Intake -3 Screening - 2009-054 – Incomplete -7002 78th AVE SE, MERCER ISLAND

Here is resubmission on responses to Intake -3 comment and action progress.

BY: T.N.
 DATE: 7/29/20
 CHECKED: T.N.
 SHEET NO.
A0.0
 JOB NO.
TL20-12

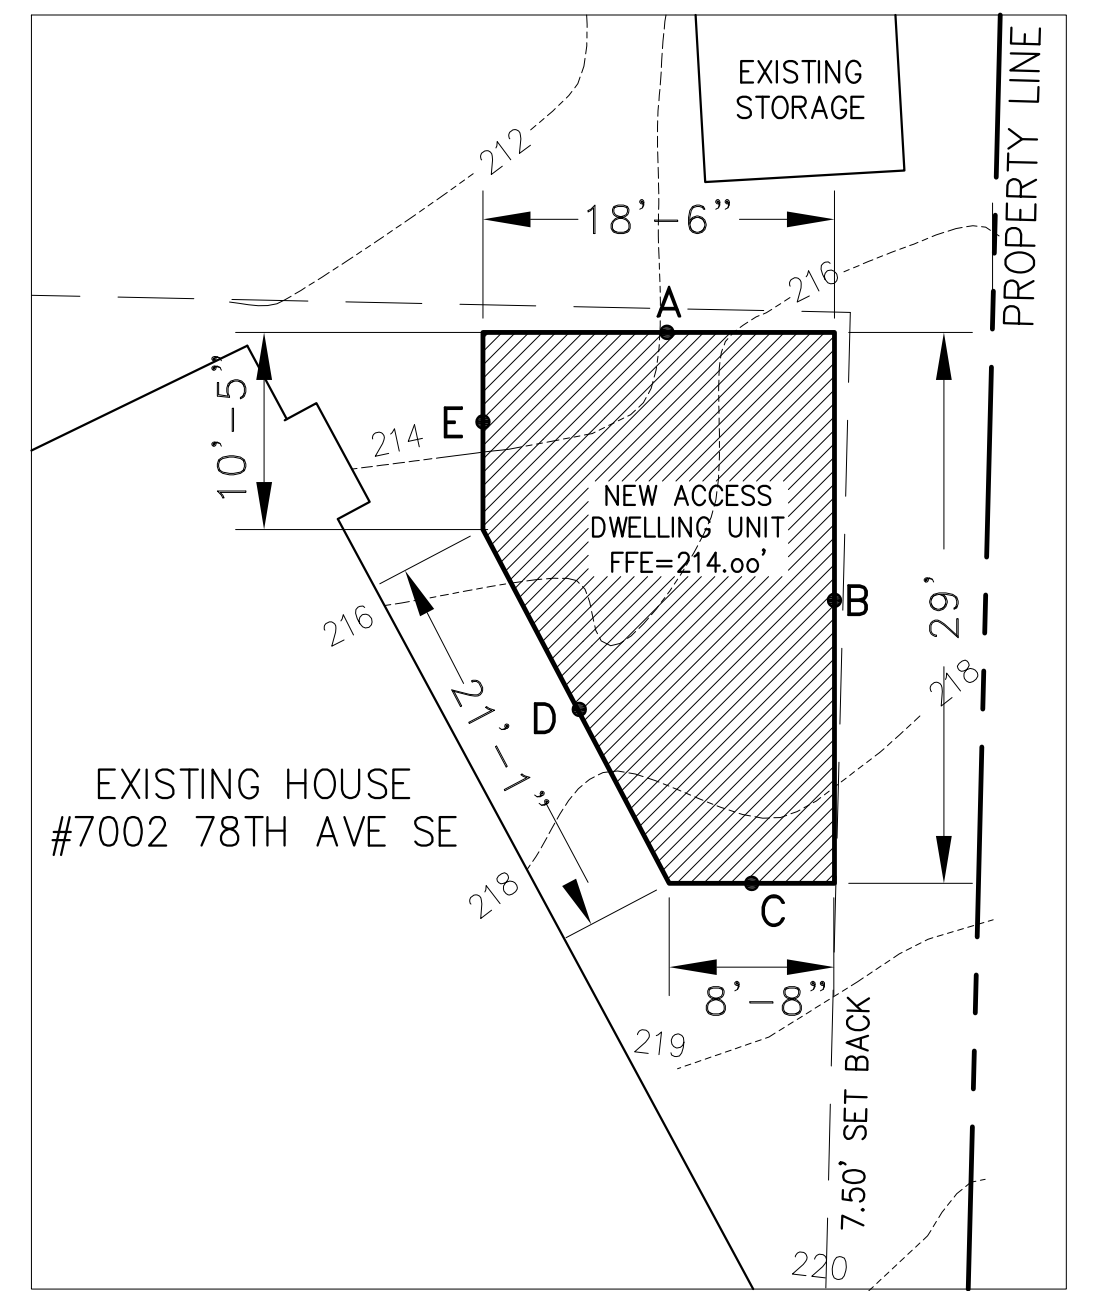
The hardscape calculations shown on sheet A0.0 are incorrect. Hardscape does not include the parking/driveway area and the building with the overhang. Lot coverage wasn't even provided, please provide this calculation. Lot coverage is all drivable surfaces (parking and driveway) and the buildings with overhangs (roof & eaves). Please keep in mind that impervious surface is different from lot coverage.

See attach on this Site plan and sent previously.

See attach on this Site plan and sent previously.

BASIC SITE PLAN

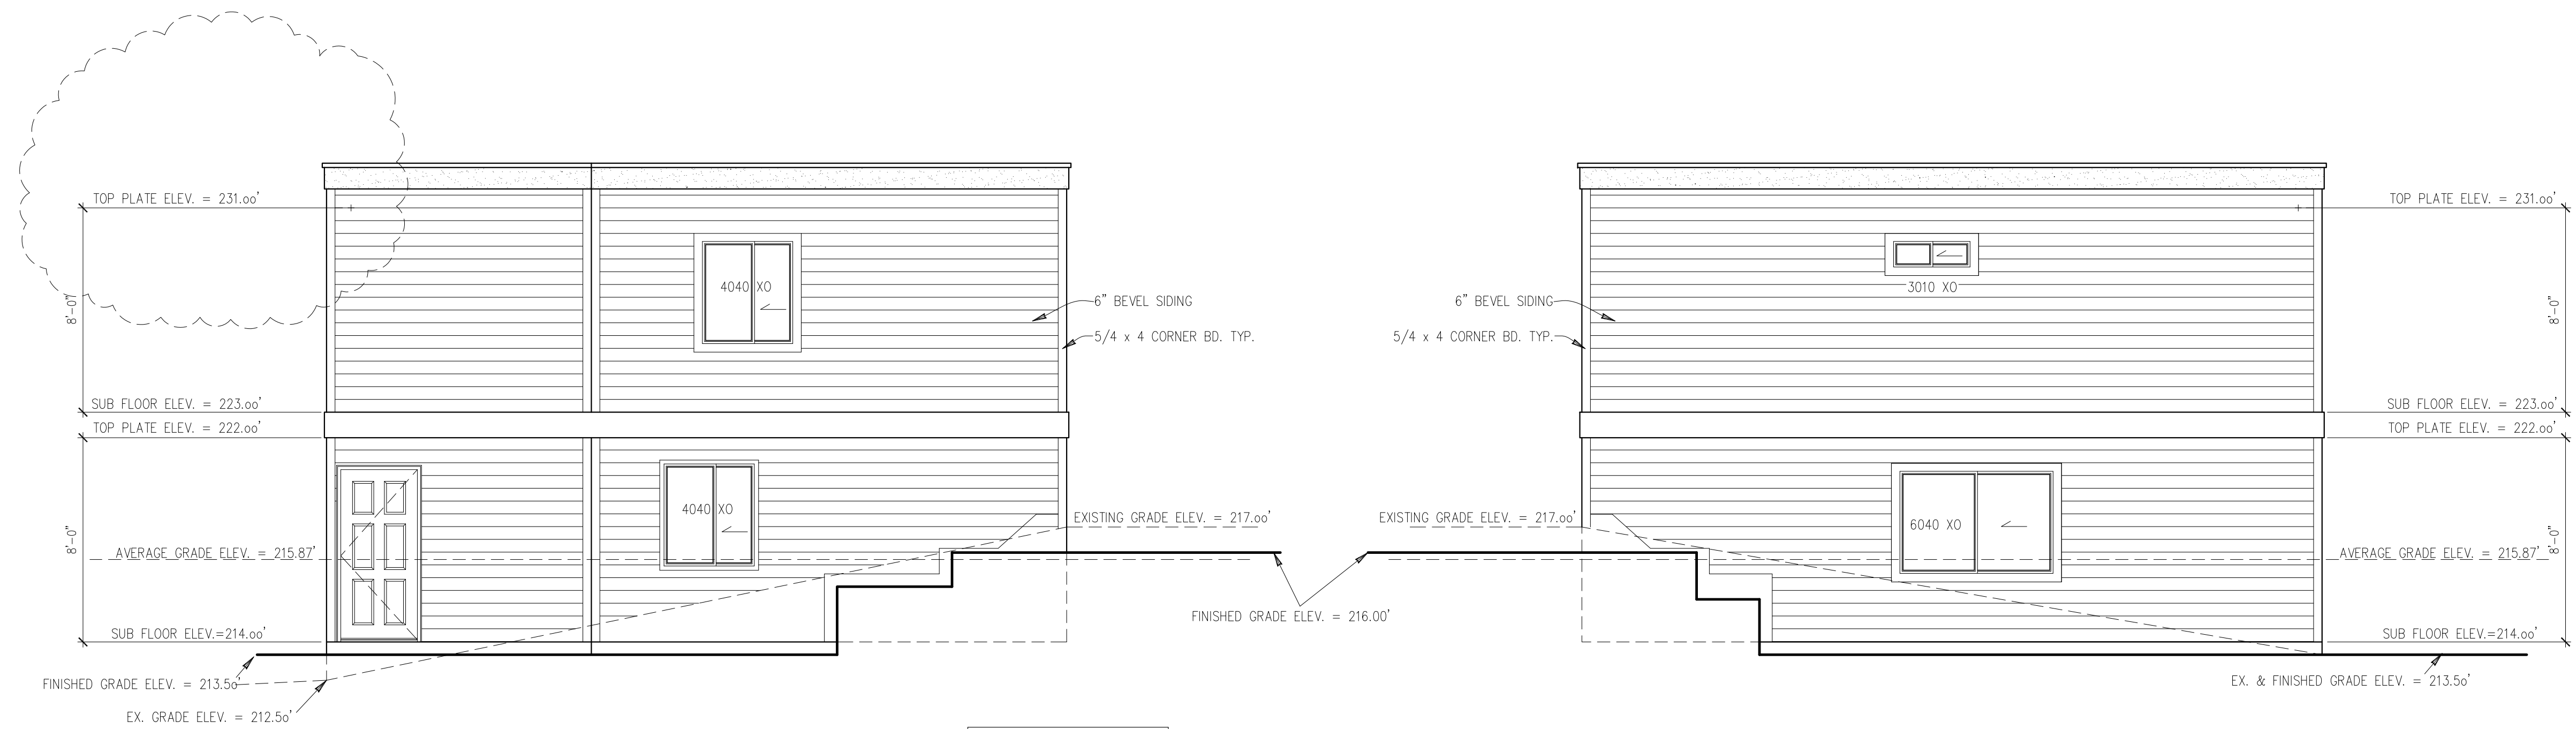
1. Trees 4,5,6 are exceptional and must be protected call out distance from tree trunk to tree protection fence. See detail

2. Two large trees look to be located in the SE corner, must be shown as protected.

Revised on site plan attached.

Revised on site plan attached.
